CITY OF ALBUQUERQUE

March 9, 2012

**Re: Storm Cloud Subdivision, Units 4 & 5
Drainage Report
Engineer's Stamp Date 2/10/2012 (H9/D022)**

CAMINO DEL VENADO
PROFILE

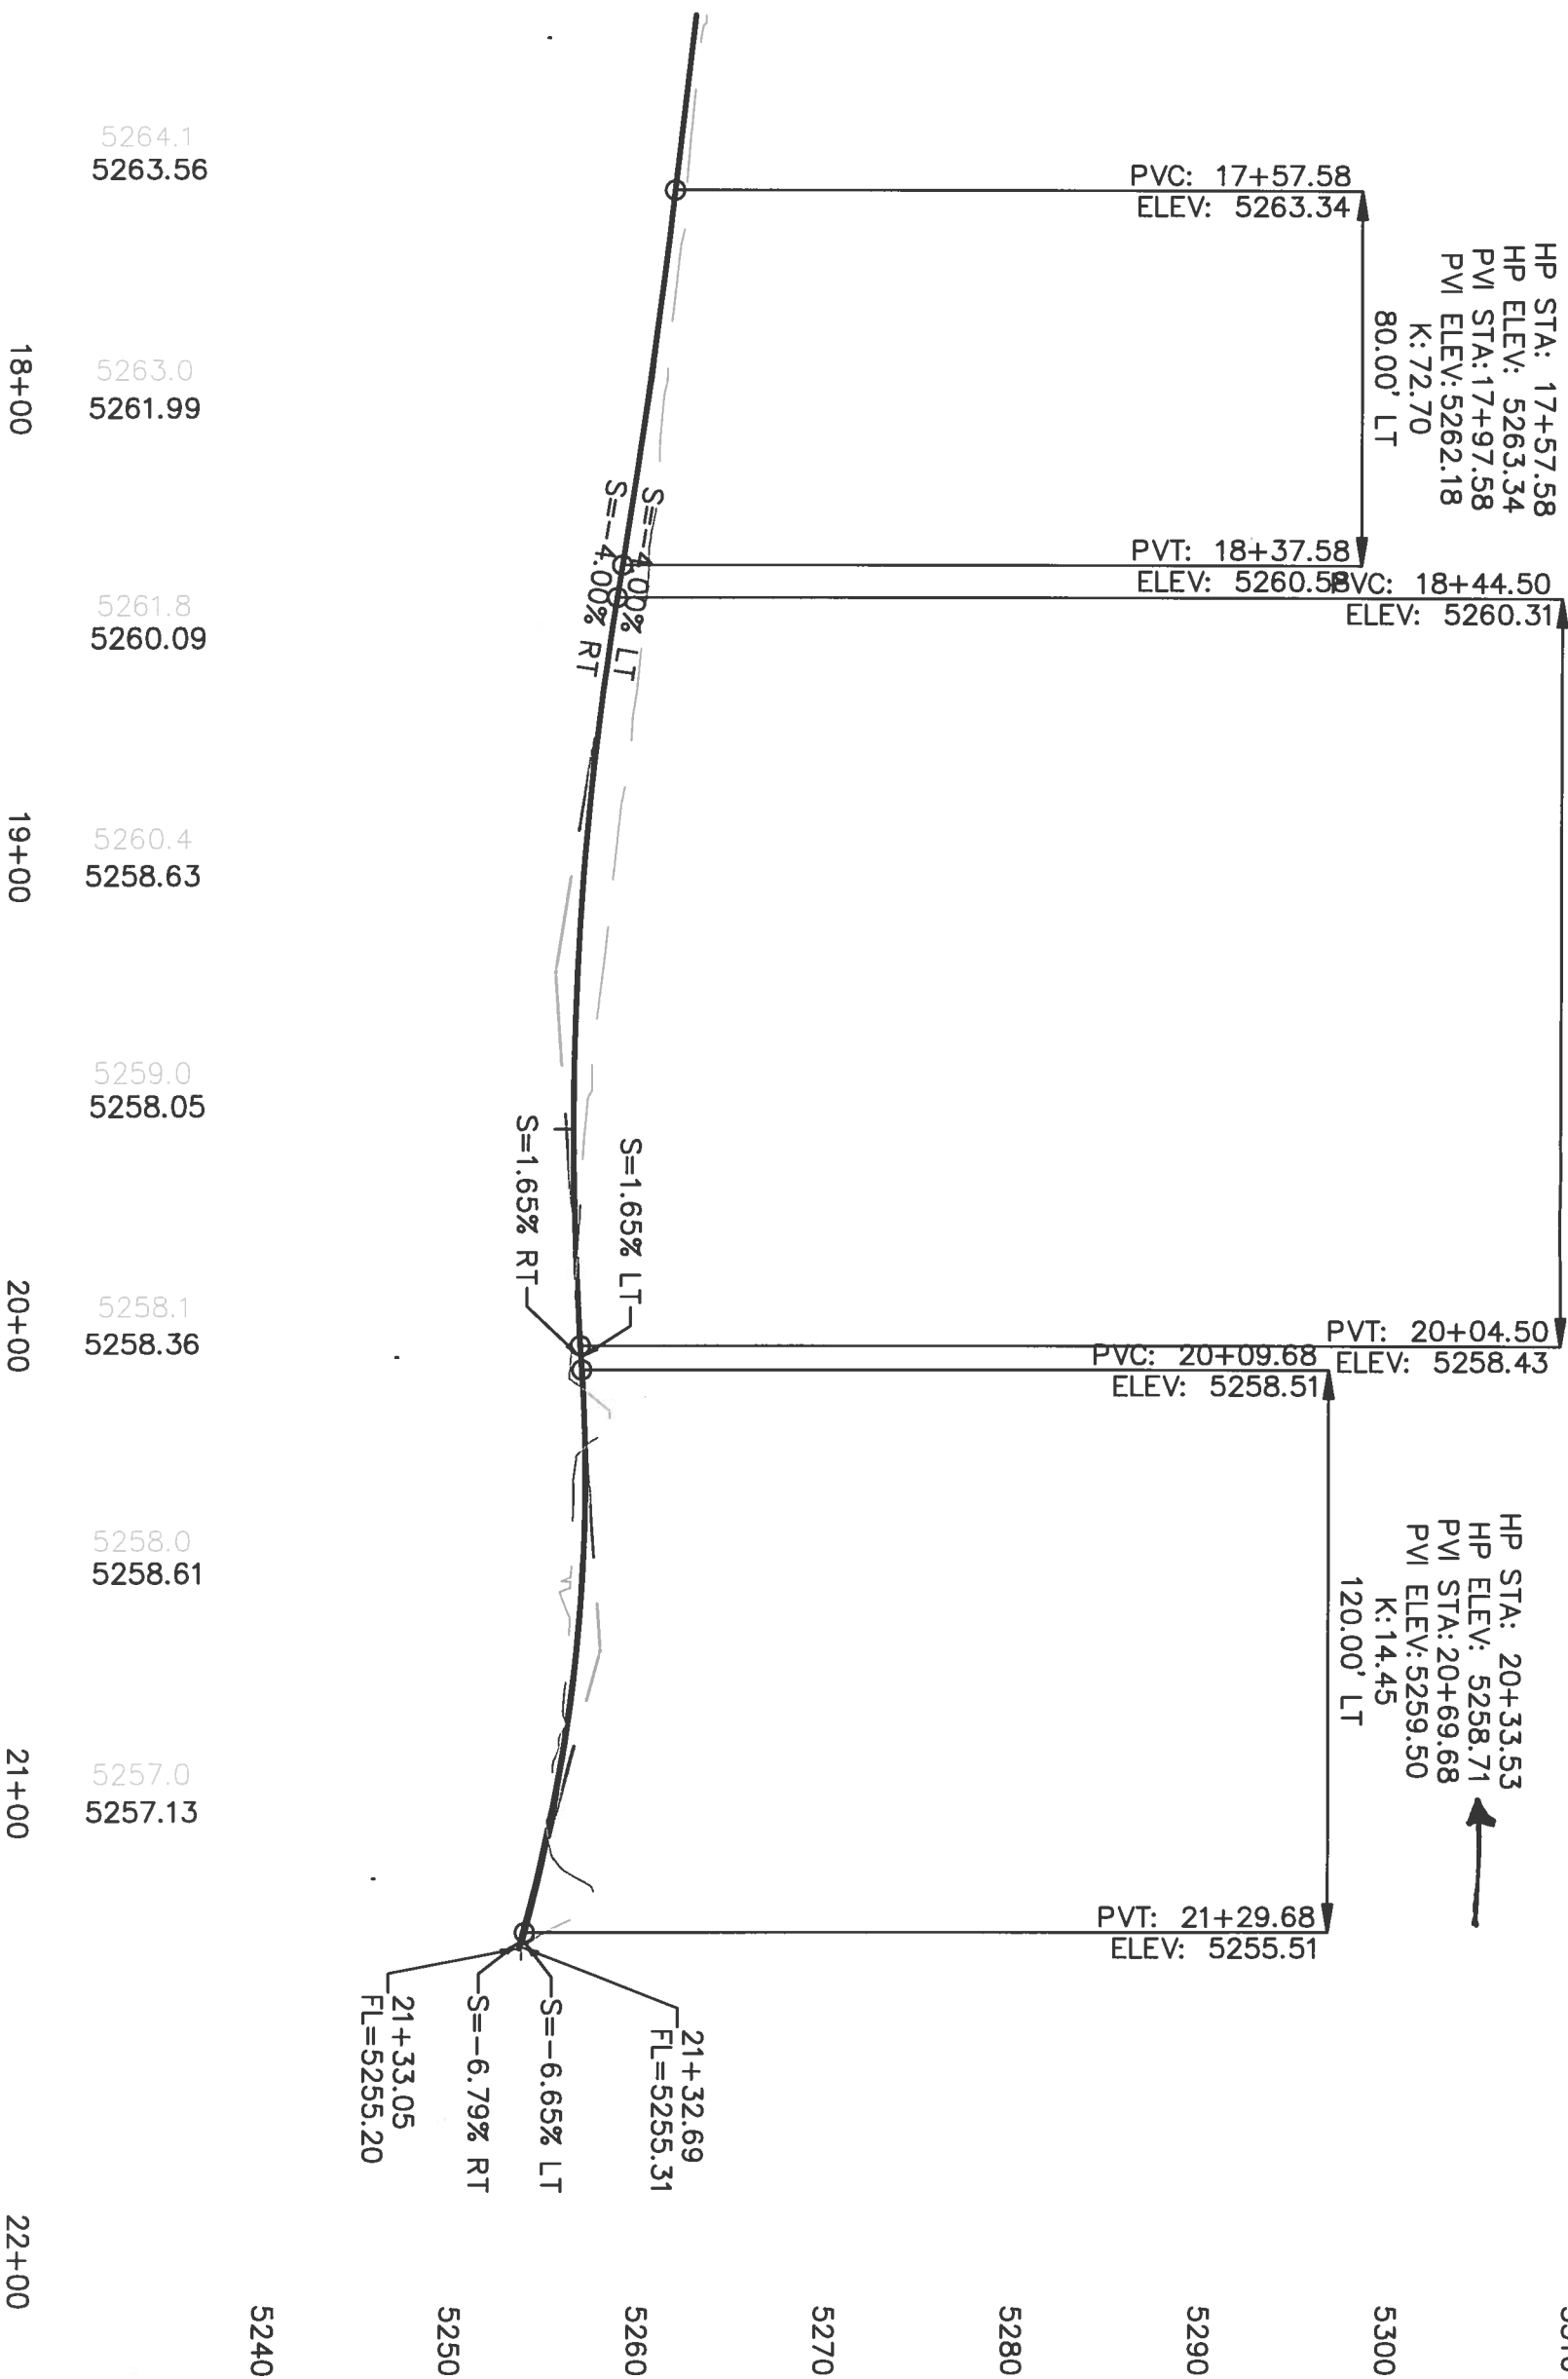
- Appendix E, Unit 4, Inlets 4 and 5 should say 5 & 6 to match the inlet numbers on the Basin Exhibit.
- Inlets 5, 6, & 7 under Unit 5, are designed to be in swamp condition. Please make sure that all three inlets are built with the same top of grate elevation and 0.67' head is provided. The runoff should not overflow to the east. The high point in the street is at 58.67' and grate elevation is at 58.04'.

STORM CLOUD UNIT 5
TERRA PINTADA BASIN
EXHIBIT

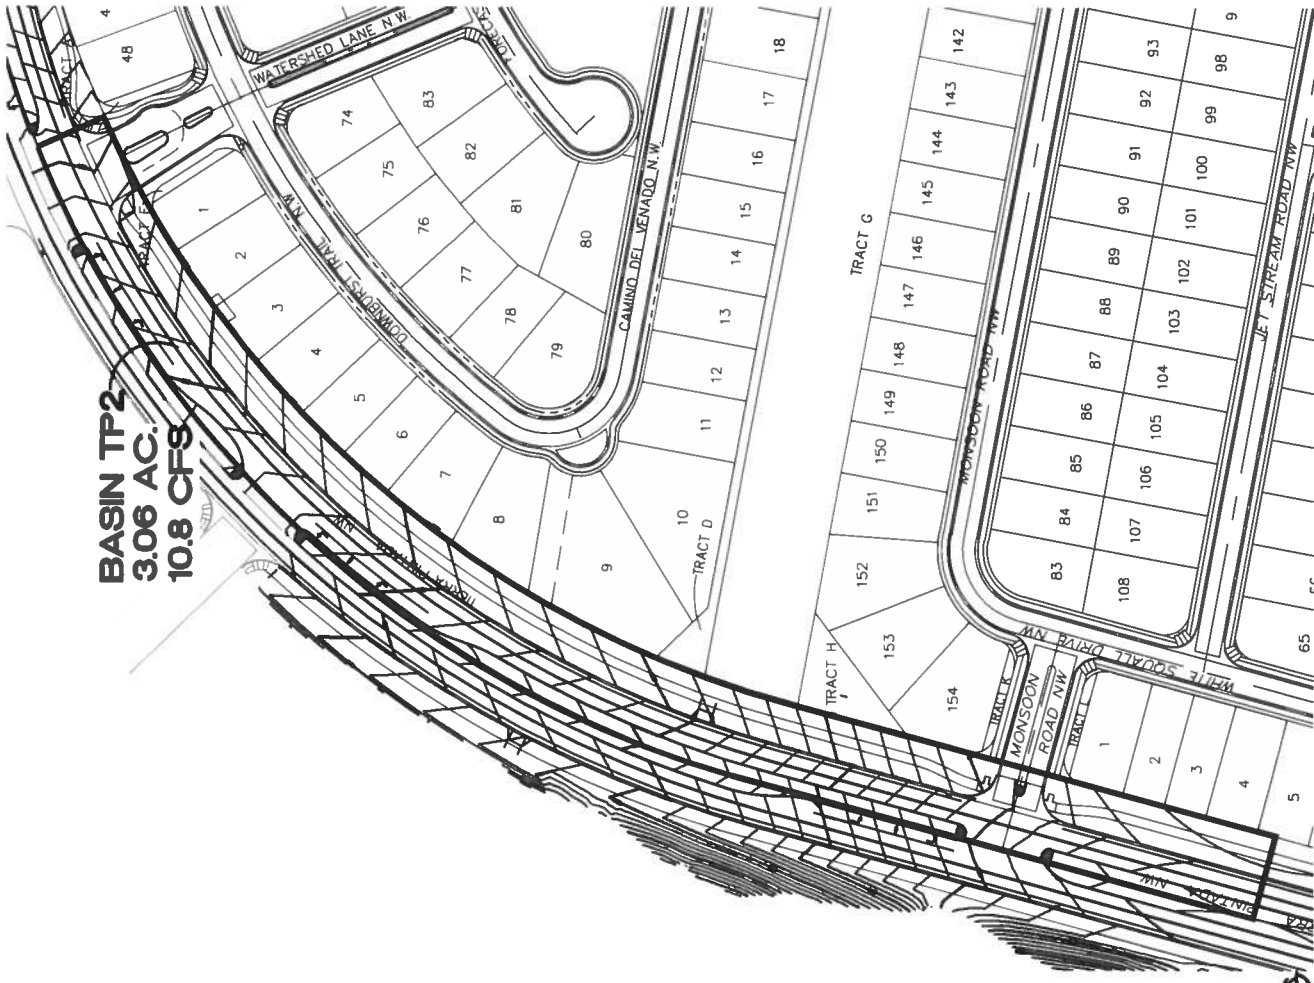
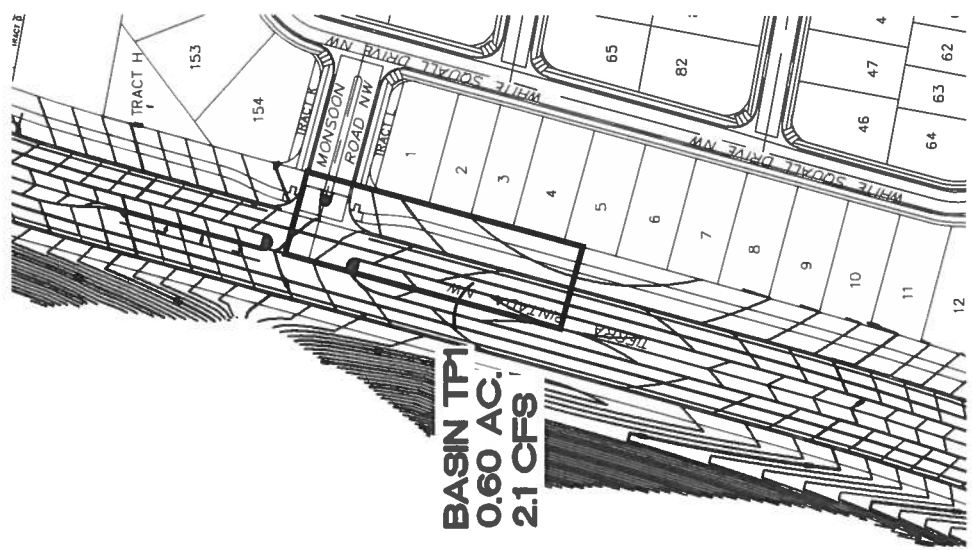
- Provide adequate water block (+/- 1') at the proposed entrances from the Tierra Pintada Boulevard.
- Include the lot number for Unit 4.
- Show the existing 36" storm drain pipe on Summer Breeze Dr.

Date:	NOV. 2011	No. Revision:		Date:		Job No.	1822
Drawn By:	ANW					PAGE	
Ckd By:						SHEET	2 OF 7

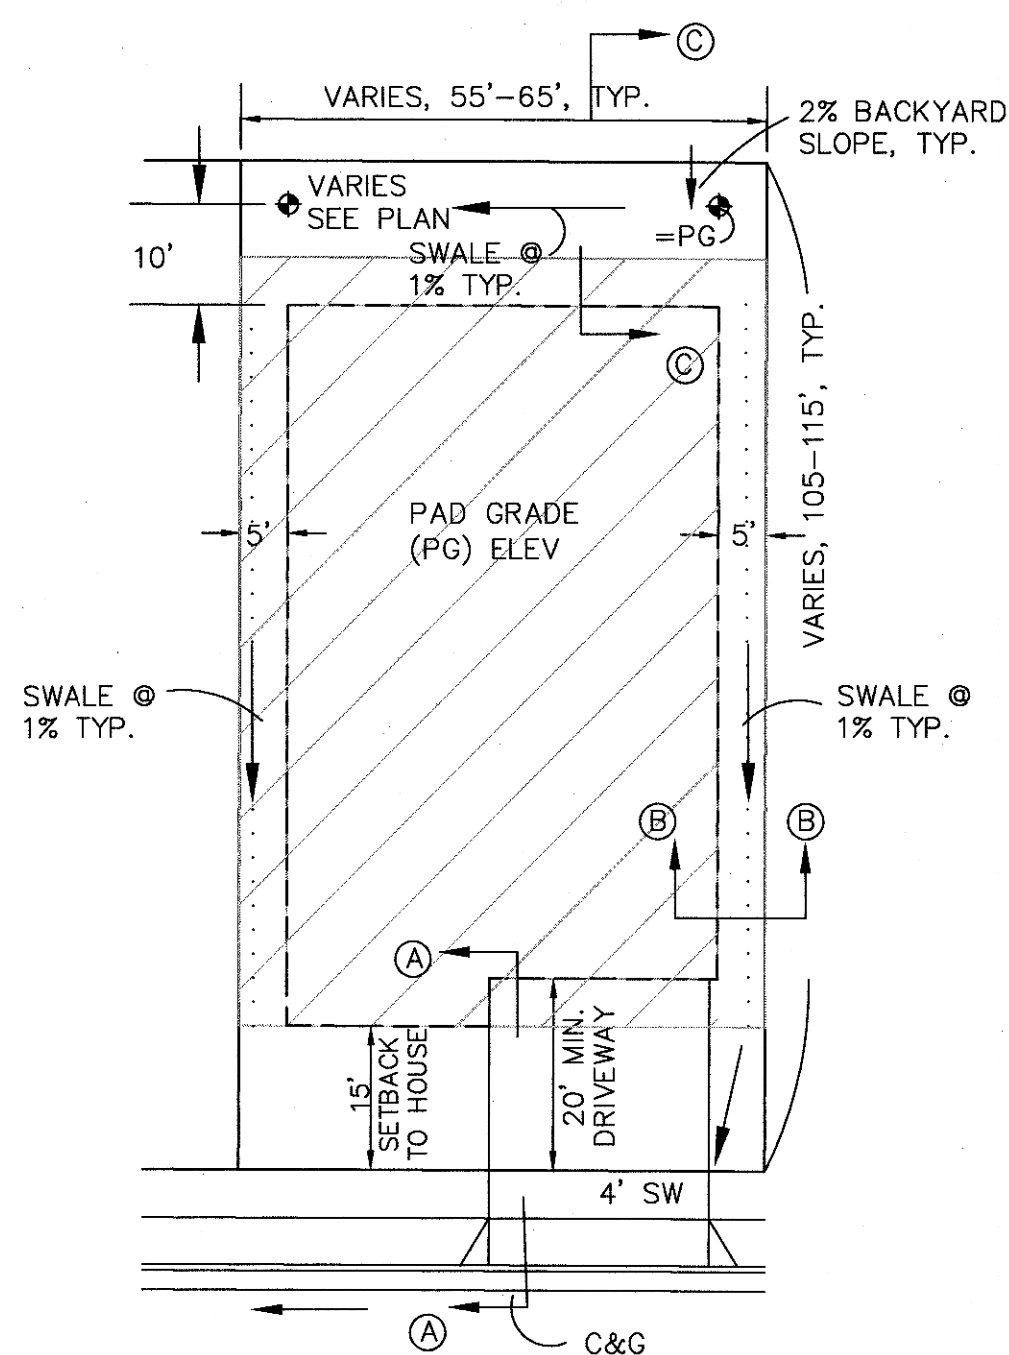
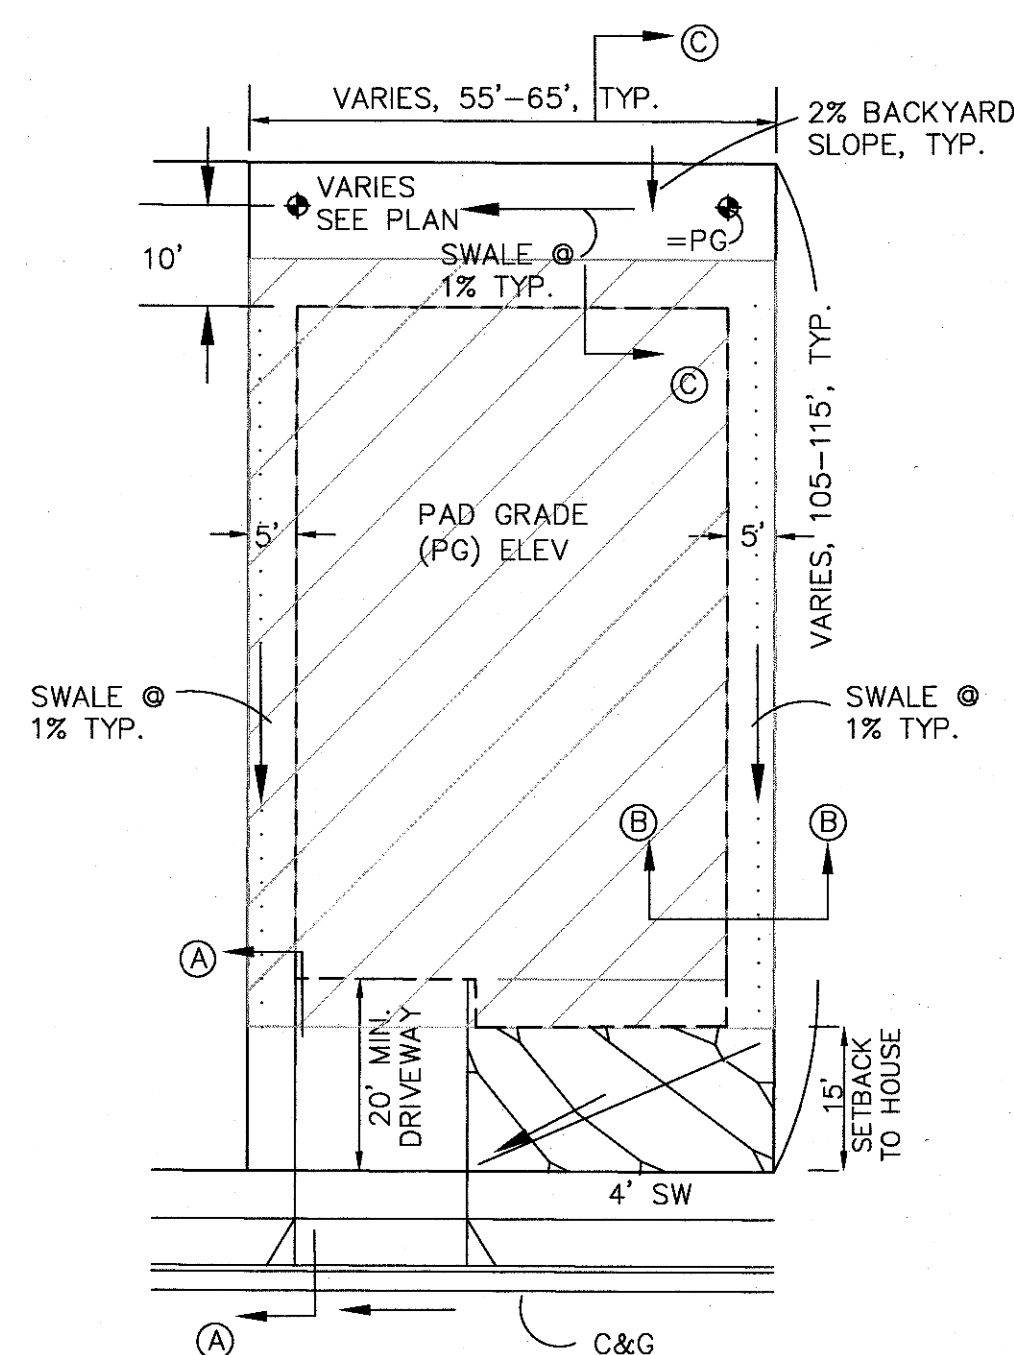
- Show proposed Tierra Pintada Boulevard and grades on the plans.
- Show proposed 3-90" RCPs and grades on the plans.
- Provide updated HEC-RAS analysis for the Mirehaven starting east of the 3-90" RCPs. Include an exhibit showing the proposed floodplain limits east of the culverts and the proposed WSEL/EGL along the Mirehaven Channel.

- Remove Mirehaven Stationing from the grading plan and include them on a separate sheet with updated channel analysis.
- Since the streets are on a slope top back of the sidewalk on one side of the sidewalk culverts will be lower. Therefore, you may have to lower the invert of the sidewalk culverts to insure the 0.67' head is provided.

- Fix the text overlaps on the grading plans.
- Clearly show all the existing retaining walls, and label the retaining walls that will be removed.
